## RESPONSE TO AGENCY SUBMISSIONS

# 10749 - North Penrith Stage 2A Project Application

NORTH PENRITH
STAGE 2A LOT LAYOUT

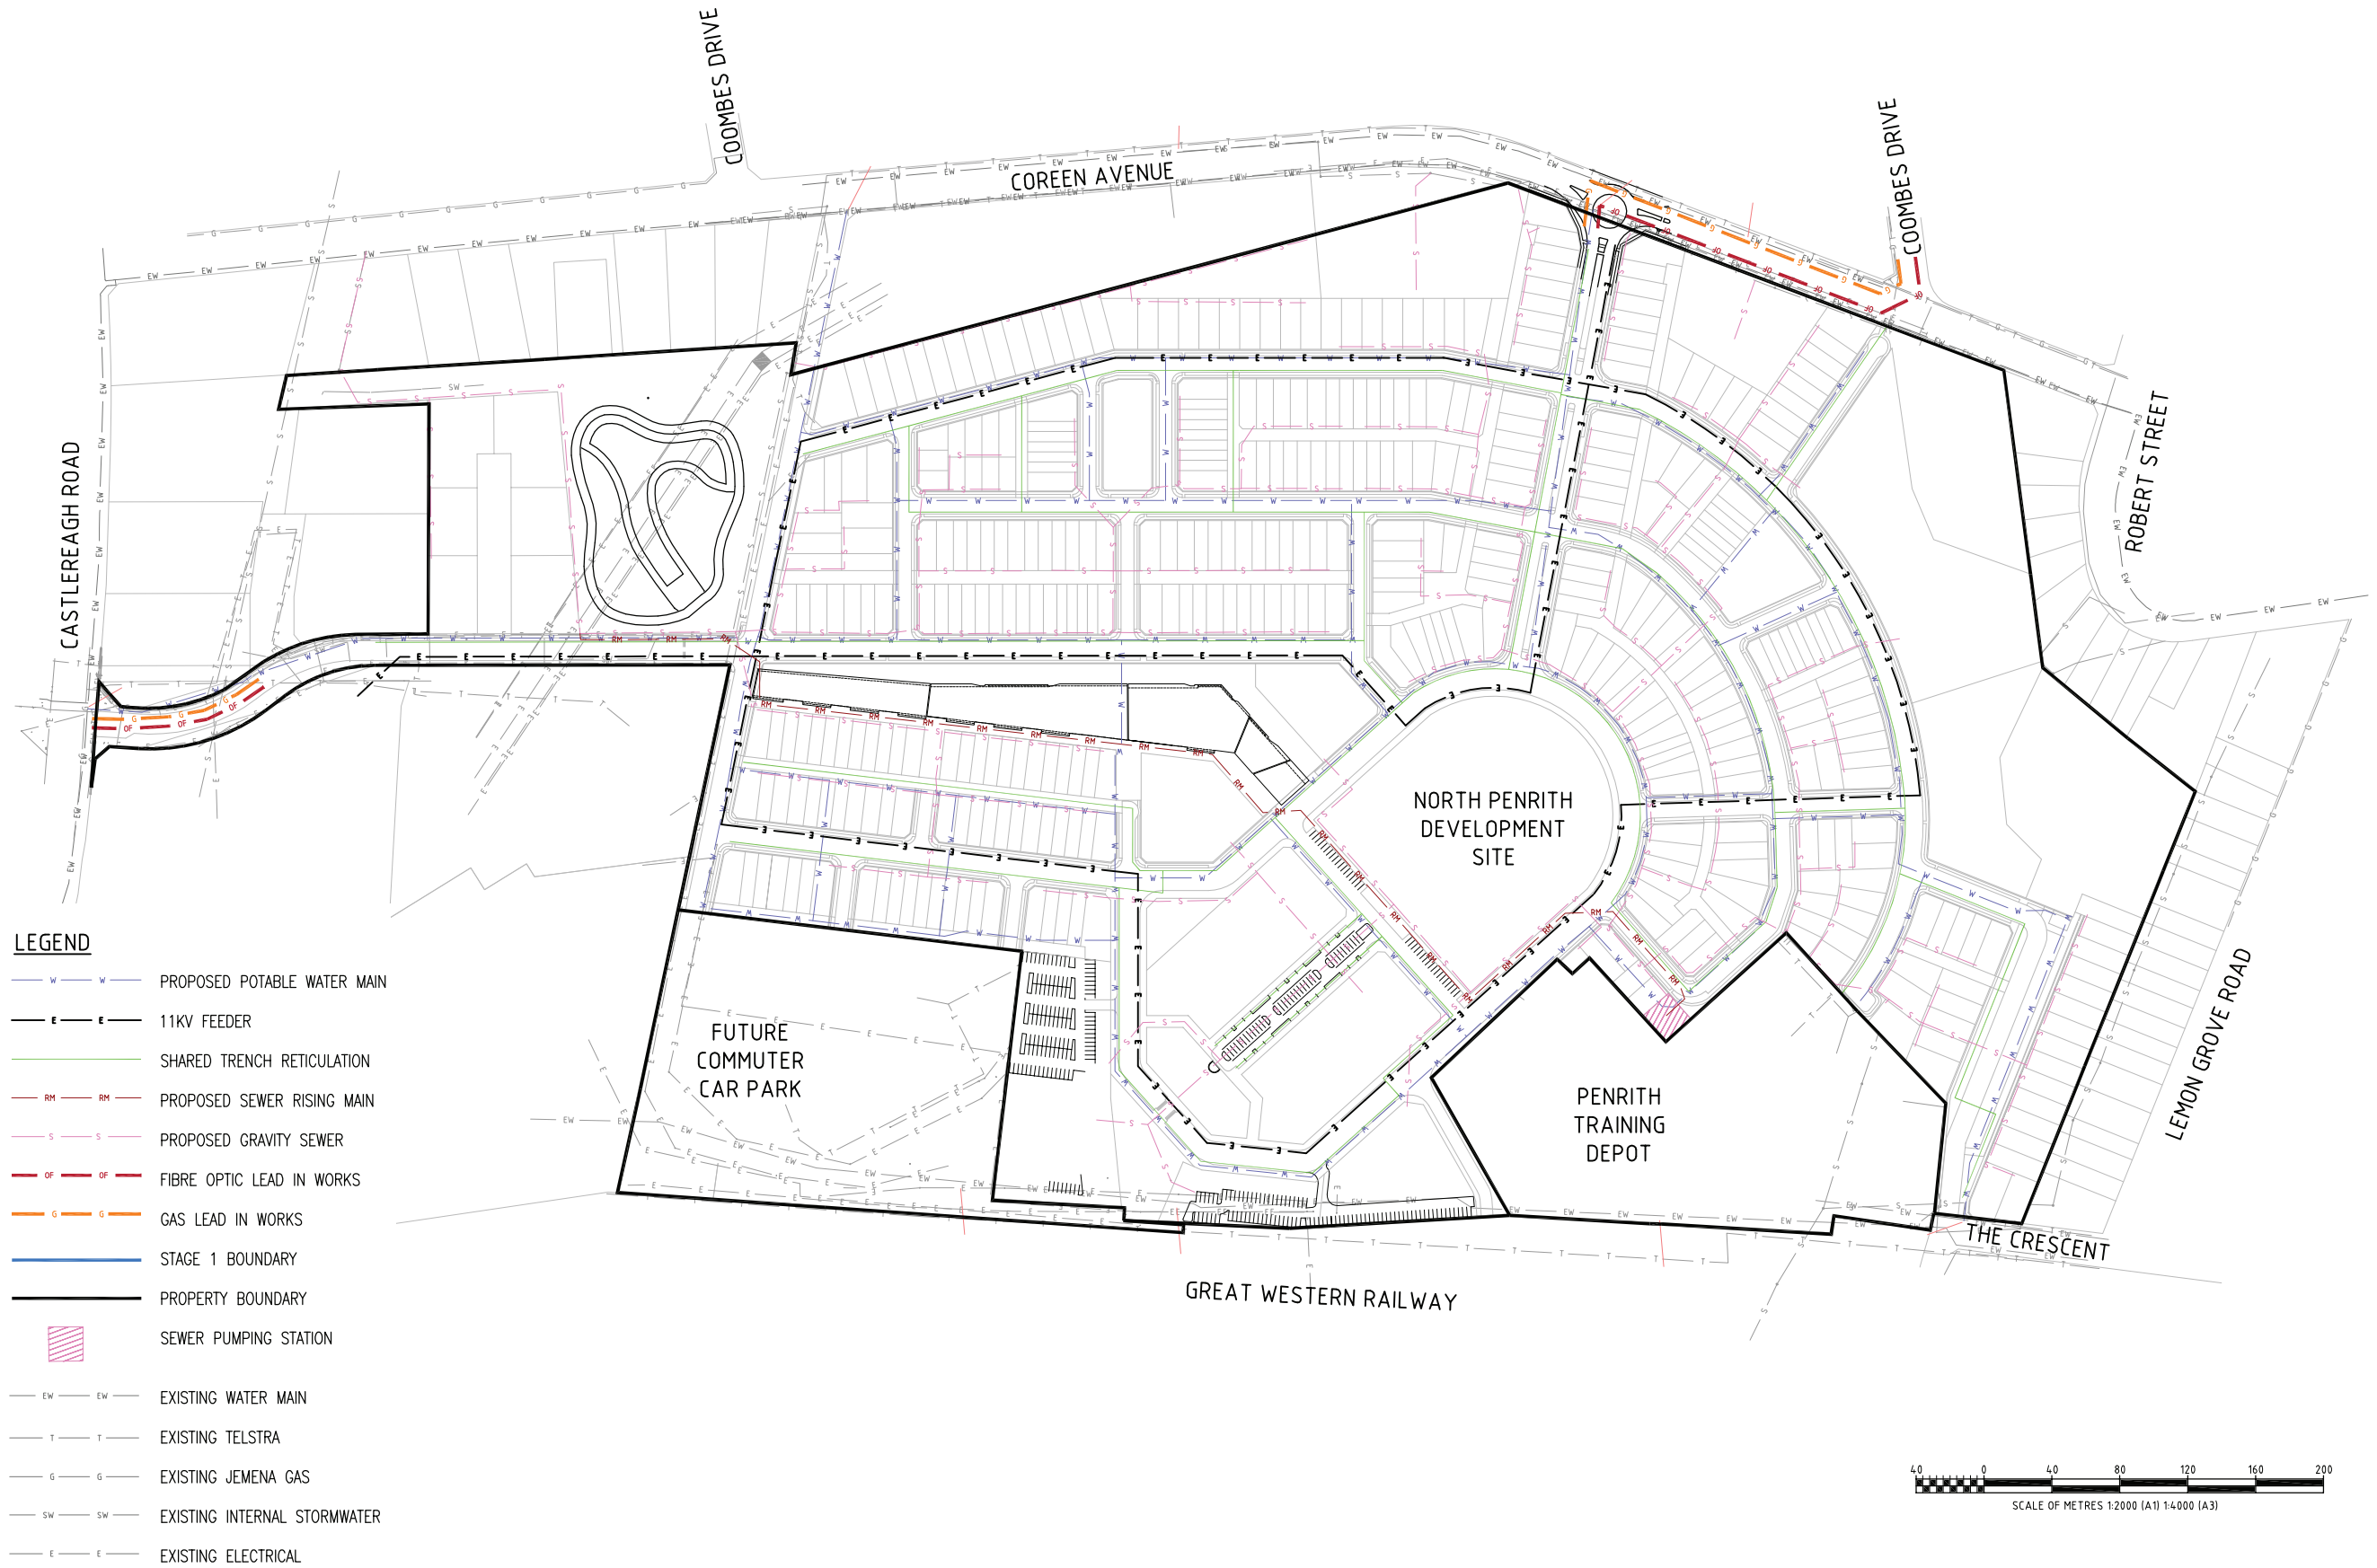
Issues Raised	Response
<ul style="list-style-type: none"> <li>▪ There appears to be a discrepancy in relation to the proposed lot distribution. In particular, the following distribution is to be confirmed:                             <ul style="list-style-type: none"> <li>▪ 27 residential lots, as labelled on 'the submitted plan and including proposed lots 2001, 2002, 2003, 2004, 2005, 2006, 2007, 2008, 2009, 2010, 2011, 2012, 2013, 2014, 2015, 2016, 2017, 2018, 2019, 2020, 2021, 2022, 2023, 2024, 2025, 2026, 2027.</li> <li>▪ 3 integrated housing lots, as labelled on the submitted plan and including proposed lots 2029, 2030, 2031.</li> <li>▪ 1 super lot for apartments, as labelled on the submitted plan and including proposed lot 2032. It appears that the area of this allotment is incorrect in Table 2 of the Environmental Impact Statement.</li> <li>▪ 1 heritage lot, as labelled on the submitted plan and including proposed lot 2028.</li> <li>▪ 1 open space lot, as labelled on the submitted plan and including proposed lot 2033.</li> </ul> </li> </ul>	<ul style="list-style-type: none"> <li>▪ Stage 2A seeks consent for the following lot distribution as shown on the Draft Plan of Subdivision prepared by Craig and Rhodes which was provided at Appendix A of the EIS:                             <ul style="list-style-type: none"> <li>▪ 31 residential lots (Proposed Lot Nos. 2001 - 2031);</li> <li>▪ 1 integrated housing site with a proposed yield of 4 dwellings (Proposed Lot No. 2033);</li> <li>▪ 1 super lot for apartments (Proposed Lot No. 2034);</li> <li>▪ 1 heritage lot (Thornton Hall and curtilage) (Proposed Lot No. 2032);</li> <li>▪ 1 open space lot (Thornton Park) (Proposed Lot No. 2035); and</li> <li>▪ Road reserve (Mountain View Crescent).</li> </ul> </li> </ul>
